WEST SUSSEX COUNTY COUNCIL CONSULTATION

TO:	Arun District Council FAO: Claire Potts
FROM:	WSCC - Highways Authority
DATE:	8 June 2021
LOCATION:	Land South of Summer Lane & West of Pagham Road Pagham
SUBJECT:	P/83/21/DOC Approval of details reserved by condition imposed under ref P/140/16/OUT relating to Condition No 6 - design code masterplan
DATE OF SITE VISIT:	n/a
RECOMMENDATION:	Advice
S106 CONTRIBUTION TOTAL:	n/a

Standard road with pavement to at least one side.

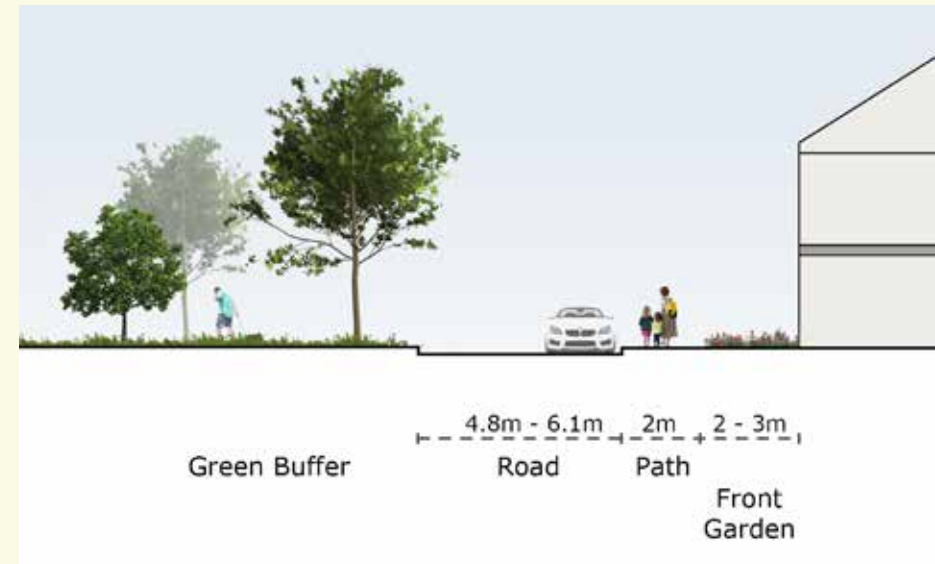
P39 – With reference to the street cross section, it's unclear why a 1.2 metre wide footway is being provided on one side of the carriageway when a 2 metres wide footway is being achieved on the opposite. 2 metre wide footways should be provided on both sides of the carriageway.

The cross section also doesn't cover the design of the shared surface indicated. A cross section should be provided.

Standard road with pavement to at least one side for this character area's spine roads. Shared surfaces to all other streets.

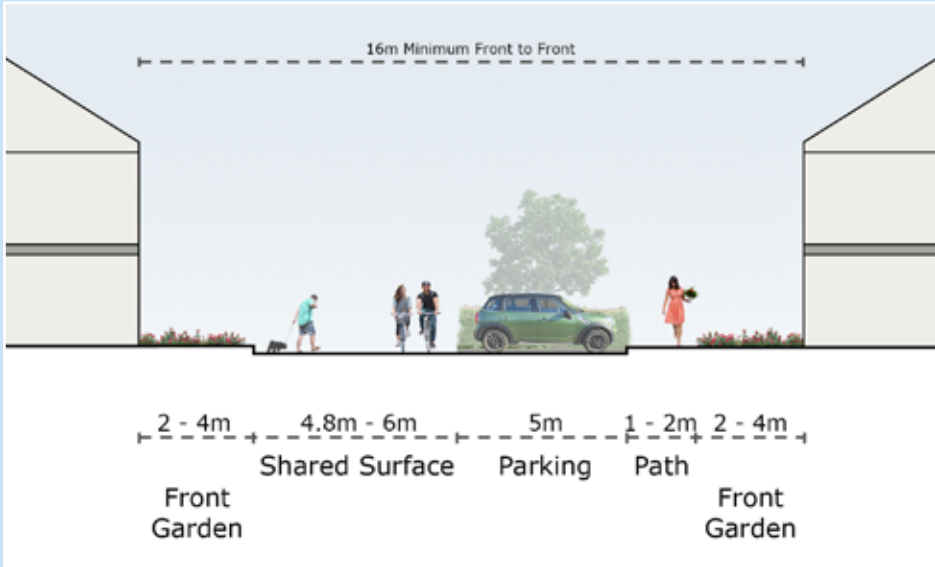
P41 – Given the nature of the road, it's unclear why the 6 to 7.3 metre carriageway widths are proposed on the cross section. These widths are greater than those proposed for the primary road. The road widths should be reduced to better reflect the intended use.

Standard road with pavement to at least one side for this character area's spine roads. Shared surfaces to all other streets.

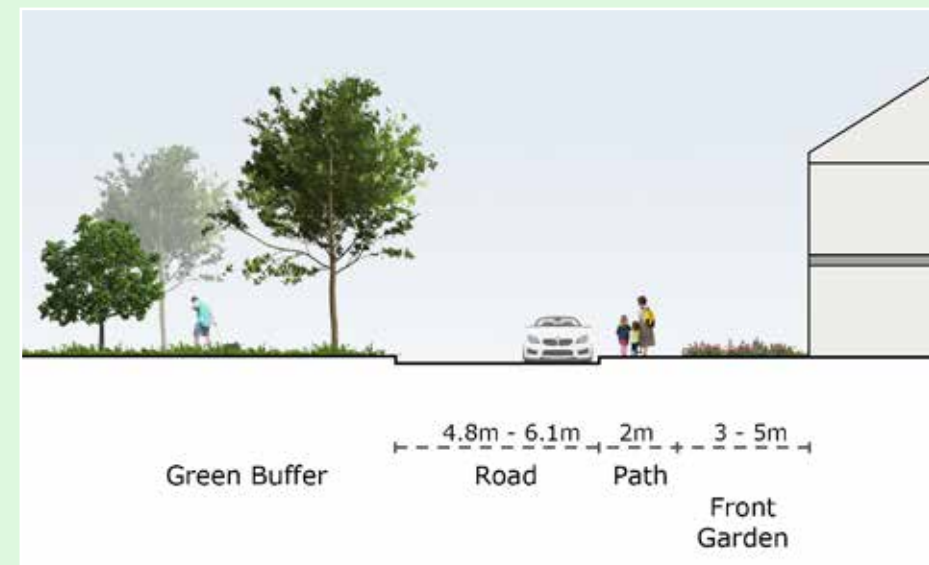
P43 – Similar to the point above, the cross section indicates potentially quite wide road widths. The 6.1 metre width seems too generous and should be reduced or at least confirmation provided that this width will not be provided continuously with there being an intention to reduce the carriageway width further into the development.
